CITY OF ALBUQUERQUE

**Re: Retail at 7 Bar
10080 & 10088 Coors Blvd NW
Conceptual Traffic Circulation Layout for DFT Approval
Engineer's Stamp 9-25-24 (B14D010D)**

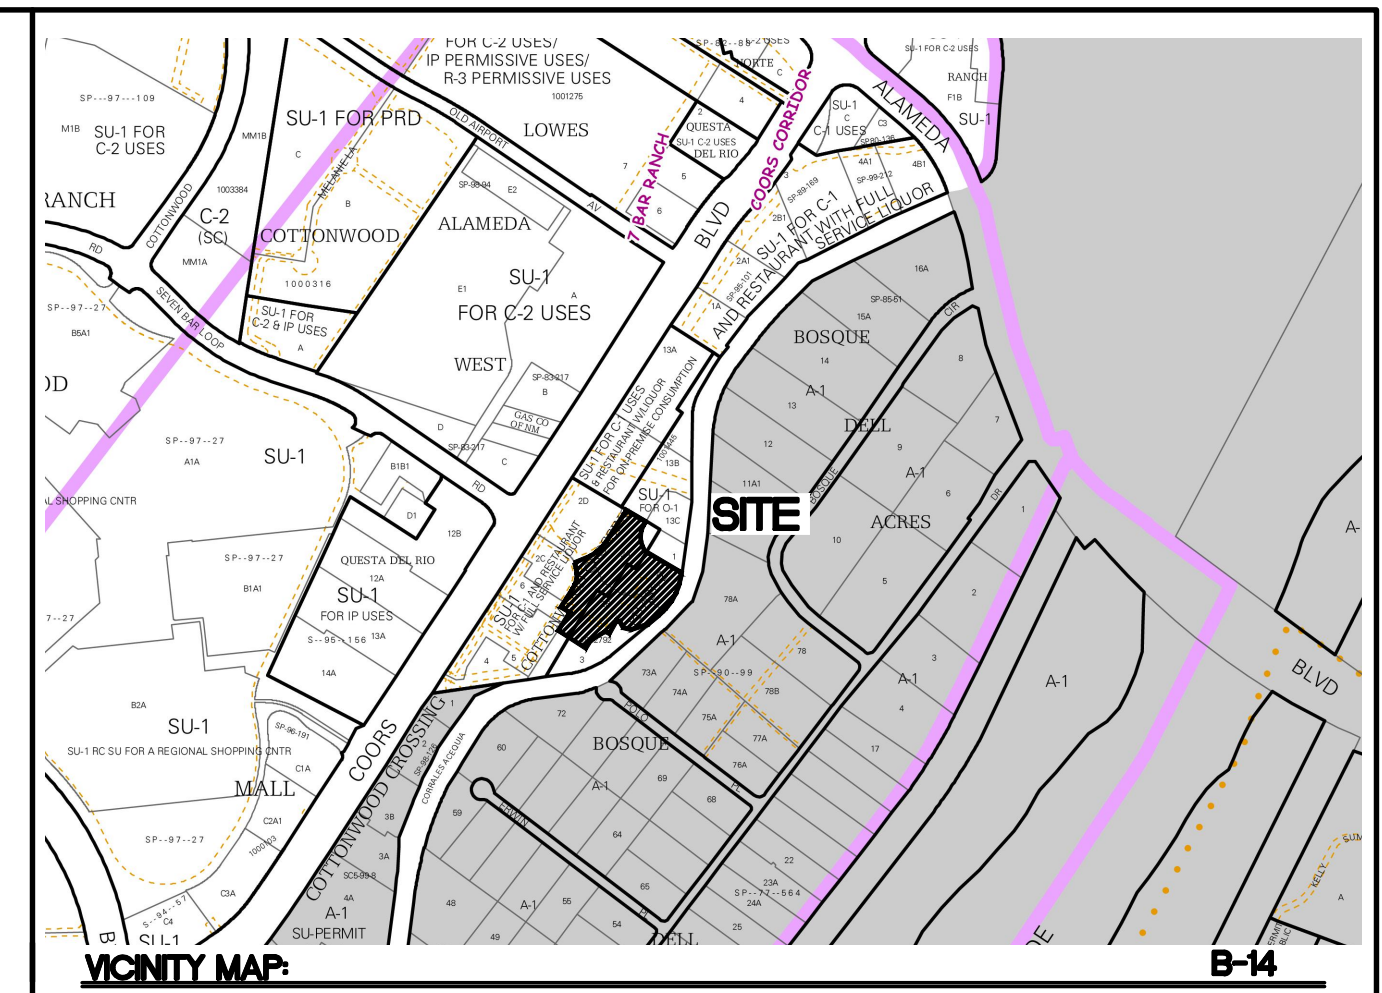
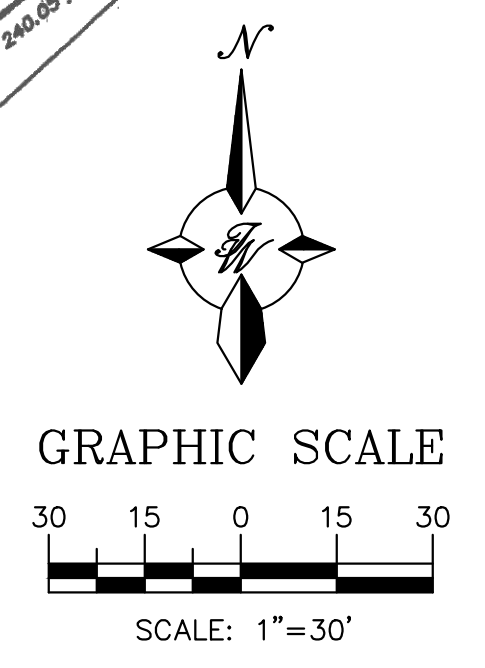
1-A 5 ft sidewalk and 4-6 ft Buffer/Landscape are required along 7 Bar loop and the access road.

2-Show all the detail drawings
